## Simonstone Parish Council

**Please find below the objections to the planning application no 3/2009/0355**

| Application number      | 3/2009/0355                                                                                                                                                                                                                                                                                                                                                                                                                                                                                                                                                                                                                             | Officer: Rachel Horton | Grid Reference<br>377567 434279 |
| Proposal                | 1 fascia sign; 4 flags (2 either side of the entrance clock); 2 hoardings either side of site set back from the road and 7 Triangular signs internal on the light posts.

Main Signage x2

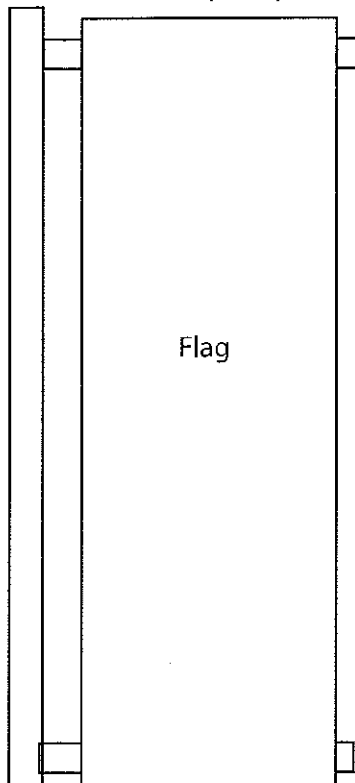
| Parish Council comments | <p>Object to the proposal on the following grounds:-</p> <p>The abundance of signs and flags is excessive and out of keeping with the rural nature of the area.</p> <p>The flags and hoardings would obstruct the view along the Road and are overly large They would cause a distraction to passing drivers, at the junctions of both Simonstone Lane and the entrance points of adjacent car parks</p> <p>The internal triangular signs would be excessive in number and create a precedent</p> <p>They would cause a distraction to passers-by and road users.</p> <p>There is no objection to the back lit sign at the entrance</p> |                        |                                 |
